PITT ST SOUTH

RESPONSE TO:
REQUEST FOR ADDITIONAL INFORMATION
19/10/2020 NSW DPIE
12 NOVEMBER 2020

1. BUILDING FACADE

Figure 1 Comparison of GRC column locations and depth

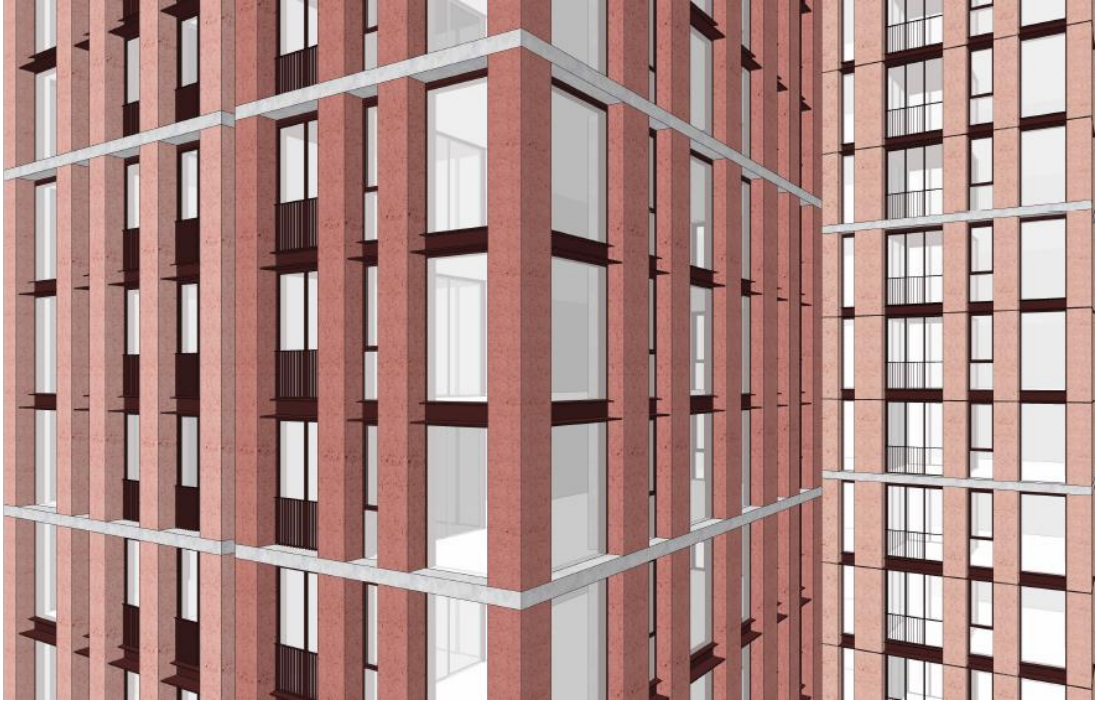
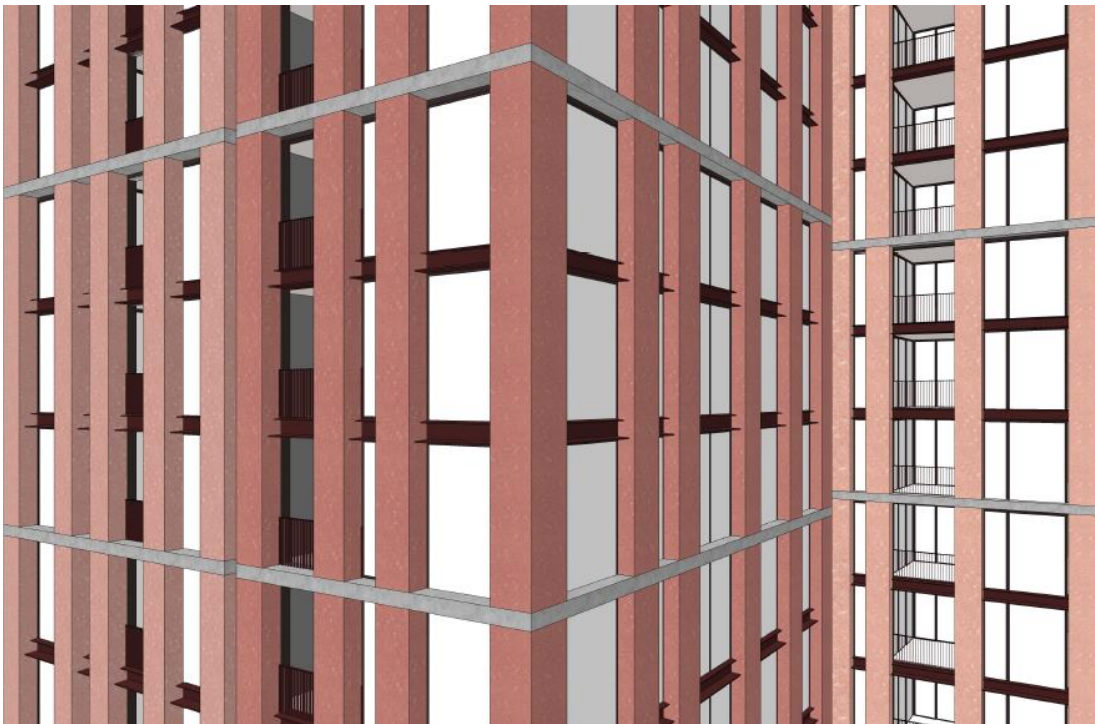
Address the impacts associated with reducing the number of GRC columns on:

- / The overall design of the project*
- / The thermal energy performance of the project.*
